**KIRKLEES METROPOLITAN COUNCIL
INVESTMENT & REGENERATION SERVICE**

DELEGATED DECISION TO DETERMINE PLANNING APPLICATIONS

Reference No:	2024/62/91592/E
Site Address:	Madressah Muhammadia Ghausia, 111, Dark Lane, Batley, WF17 7PW
Description:	Erection of extension and alterations
Recommending Officer:	Edward Cheseldine

Officer Report

**PROPOSED SITE / ROOF PLAN**

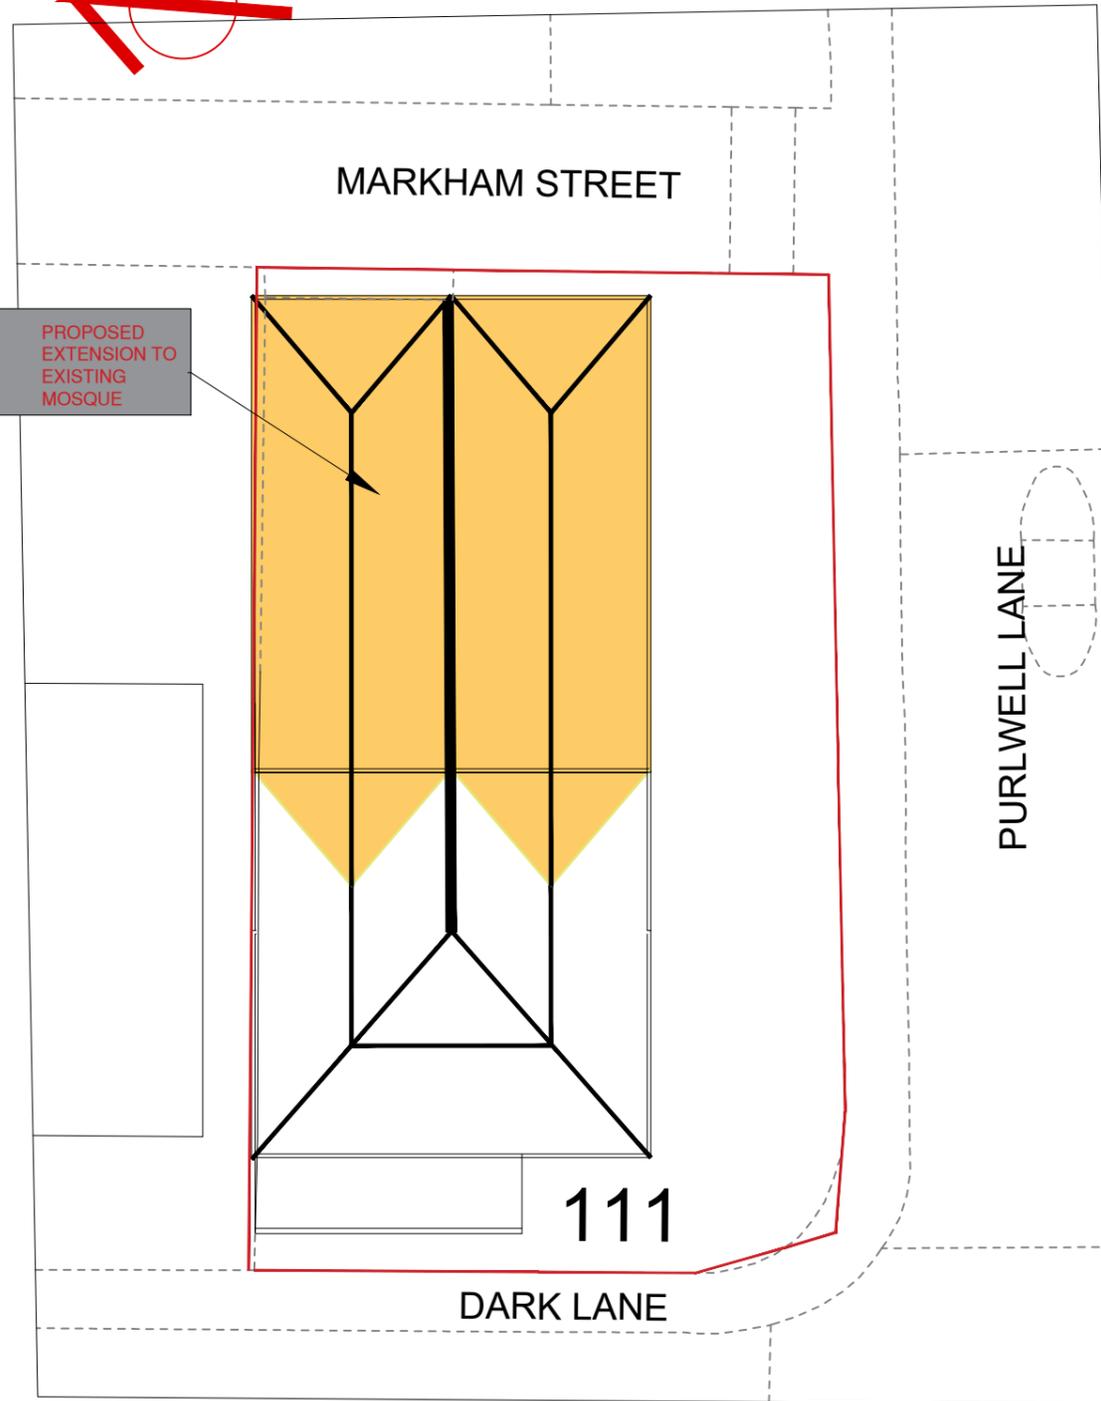
The extension would sit adjacent to Markham Street, plans indicate it would be set back from the boundary by 0.80m. Given the height of the structure, the sense of openness on Markham Street would be dramatically reduced at this point and when approaching the building. Although a back street, it provides a low traffic route to Purlwell School. Buildings adjacent to the road are typically single-storey structures. The application building is an end-terrace property, the rear extension would effectively close off the street.

There is a sense of openness at the junction between Purlwell Lane and Dark Lane. The application building is set away from the highway, it encompasses approximately 50% of the depth of the plot. As such, this section of the streetscene appears relatively open on the category C road. Purlwell Lane is a busy road connecting the Mount Pleasant suburb with Batley Carr. It has a high volume of traffic, as such a sense of openness should be retained at the point of the important intersection.

109 Dark Lane is the adjacent residential property within the terrace row. In terms of privacy, there are no windows that will face towards the property. The extension will be formed along the shared property boundary. There is a separation distance of 1.50m between the buildings. When considering the three-storey extension to the rear of the property, there would be a loss of

The extension is separated by ~5.80m from the boundary of the school. Beyond which is an access drive for cars to park. Considering the use of this area and the distance, the extension will not lead to an overbearing impact. There would however be a loss of sunlight and an overshadowing impact on the school, including classroom windows especially during the winter months which is not acceptable.

PROPOSED SIDE ELEVATION
(South)

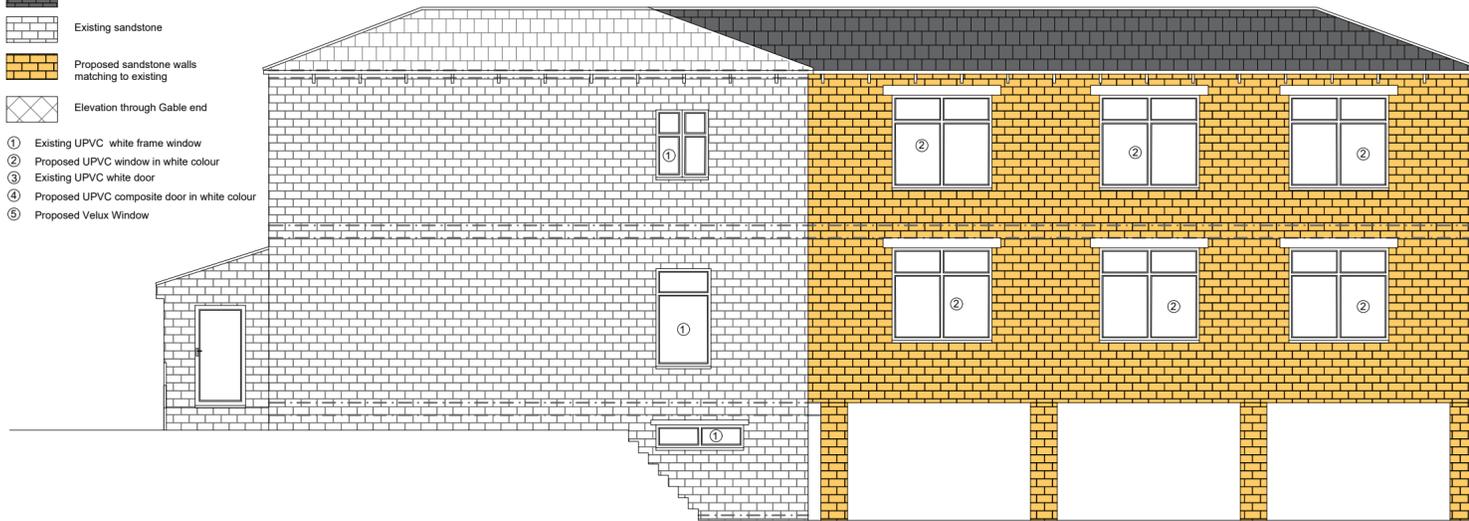
In terms of the appearance of the extension, it rests on a corner position and would be visible from Dark Lane and Purlwell Lane. In terms of Policy LP24a, the side elevation of the building should respect its prominent positioning within the townscape. When considering this elevation, it would appear as a stark structure due to its height and width. Corner plot properties should create a pleasant streetscape, not just through architectural features but

When considering, No. 85 Purlwell Lane, the structure would appear as a three-storey building with a much larger footprint. Due to its form and the gradient of the land, the application building would tower above residential buildings, in particular No 85. Such a development therefore fails to accord with Policy LP24, it would have a detrimental impact on the streetscene in terms of scale, materials and design.

The application building is currently a 2.5 storey structure with a rear outdoor parking facility. In terms of scale, the extension would effectively double the size of the structure. It would have a block form with no features present that would provide a visual break or a perception of subservience to the host dwelling. LP24c states, '*extensions are subservient to the original building, are in keeping with the existing buildings in terms of scale, materials and details*'. The design fails to respect the host building, in terms of scale and detailing. Given the size of the plot, the extension would represent overdevelopment in a cramped plot. Whilst there is parking provision on the ground-floor level, there is significant vertical massing. The appearance of the building therefore does not respect the host dwelling or size of the plot.

Purlwell School sits to the east of the application site. There are a number of first and second floor windows on the extension that look out towards the area in front of the school. Whilst the relationship is close, the front area is not considered to be private or for the use of school related activities. The front boundary of the school is formed of open slat metal fencing. It is therefore not considered that the extension would lead to a detrimental impact to privacy. There is, however, the ability for classrooms to be viewed at oblique angles. The relationship is therefore not respectful of the surrounding environment.

PROPOSED SIDE ELEVATION
(North)

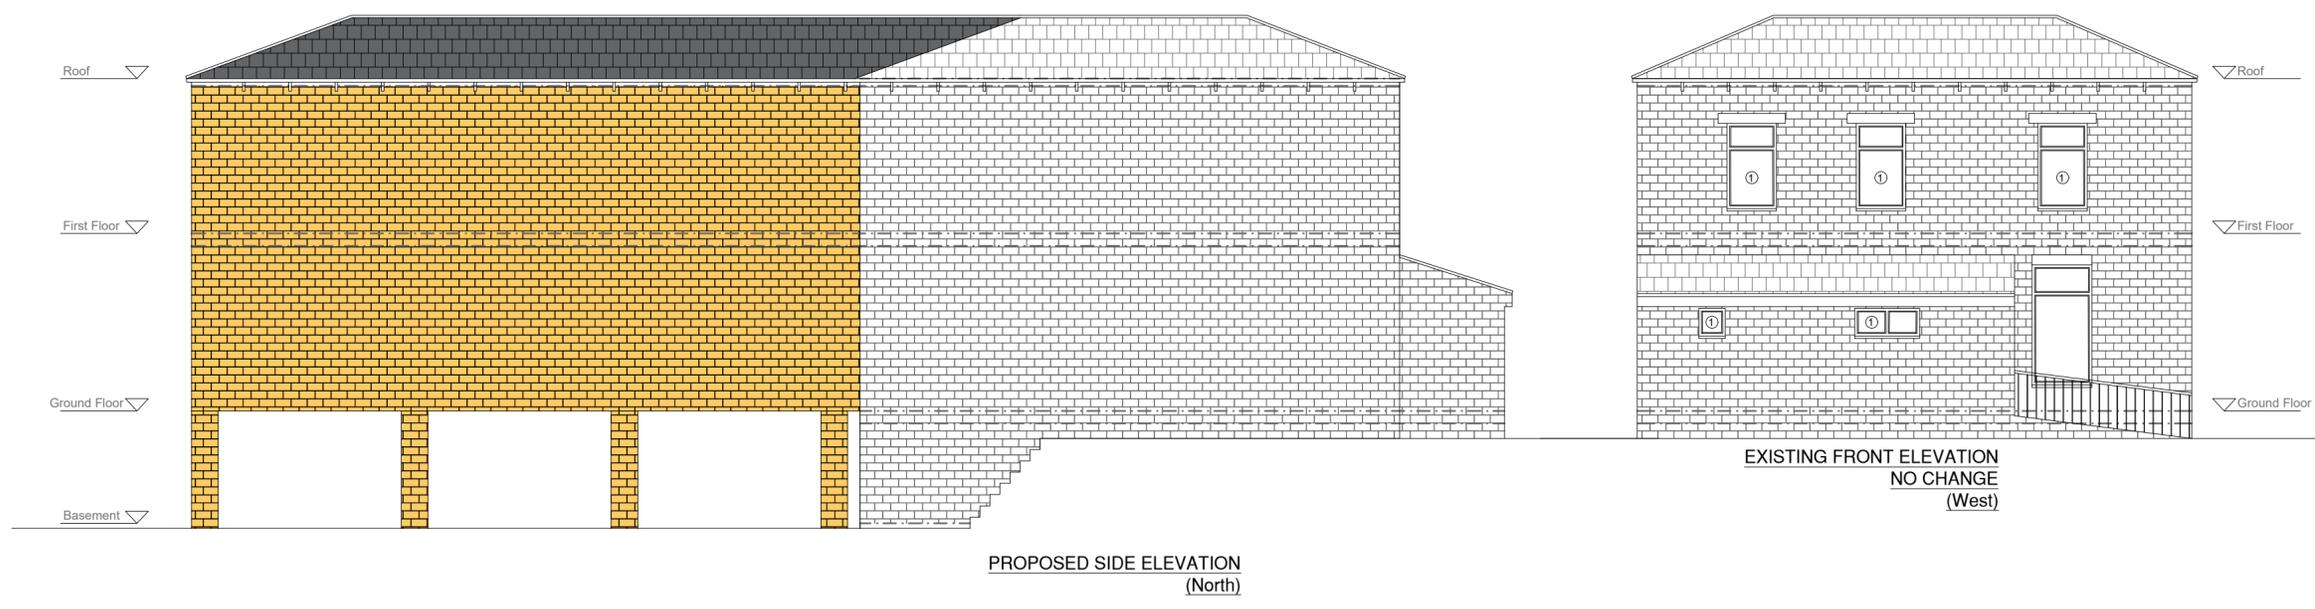
light and outlook from primary habitable windows. 109 sits to the north of the application building. Due to the height and projection of the extension, the windows would lose light from after the early morning creating an overshadowing impact. In addition, the entirety of the residential garden would be overshadowed. Such a structure would create an overbearing impact for the current and future occupants of the dwelling. The application would therefore have a detrimental impact on the amenity of the occupants of 109 Dark Lane, contrary to Policy LP24 of the KLP.

107 Dark is the adjoining property to 109 Dark Lane. Given the height and projection of the building, there would be an overshadowing impact on the entirety of the rear outdoor area from the early afternoon which would be contrary to Policy LP24 of the KLP.

PROPOSED BASEMENT /LOWER GROUND FLOOR PLAN

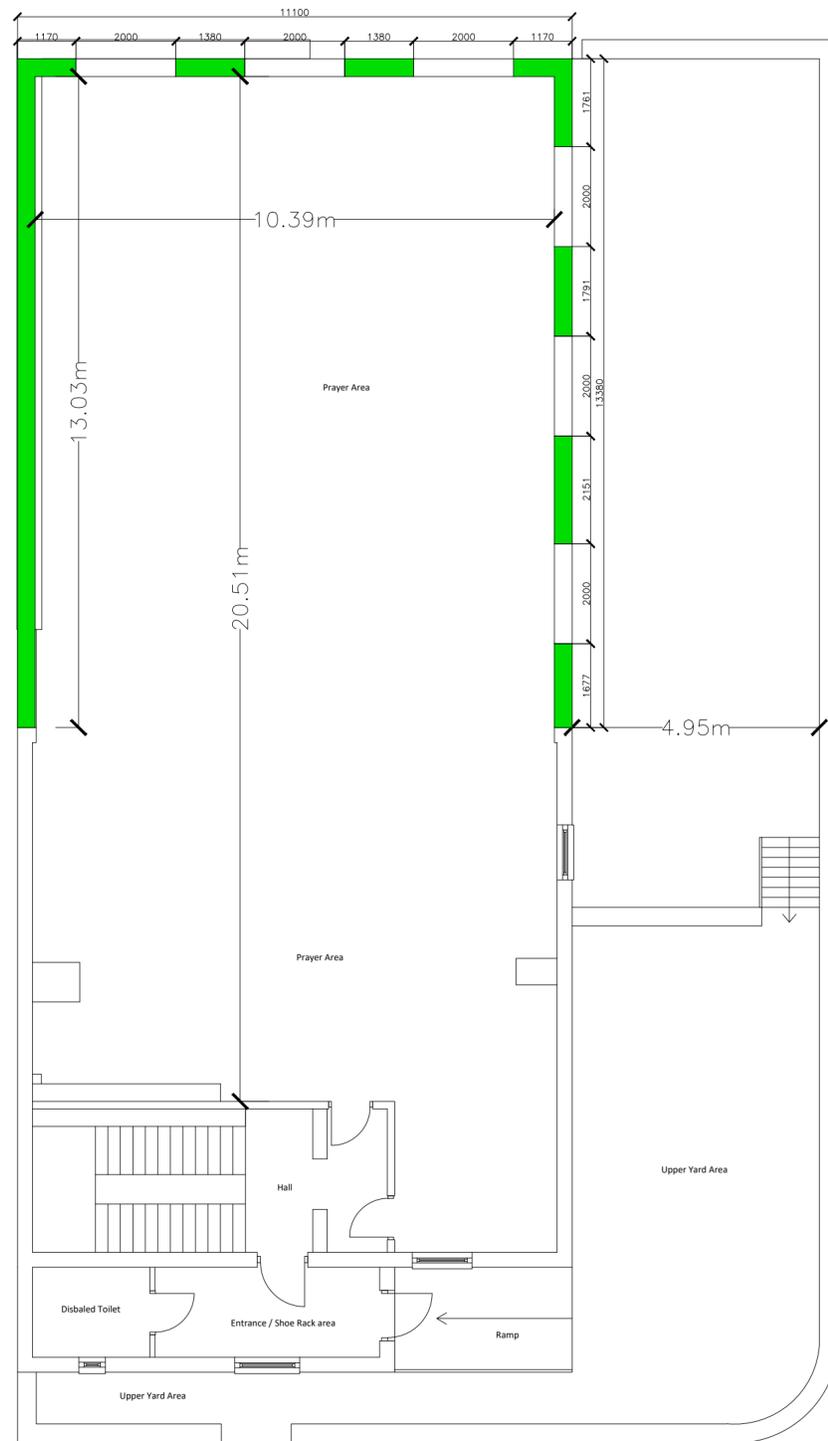
Undercroft off-street parking is shown to the lower ground floor level with access presumably from Markham Street which runs to the rear of the site. No details of the existing or proposed parking layouts are provided, however it is considered that the proposed 10 pillars required to support the extended building would reduce the capacity of the car park compared to the existing arrangements.
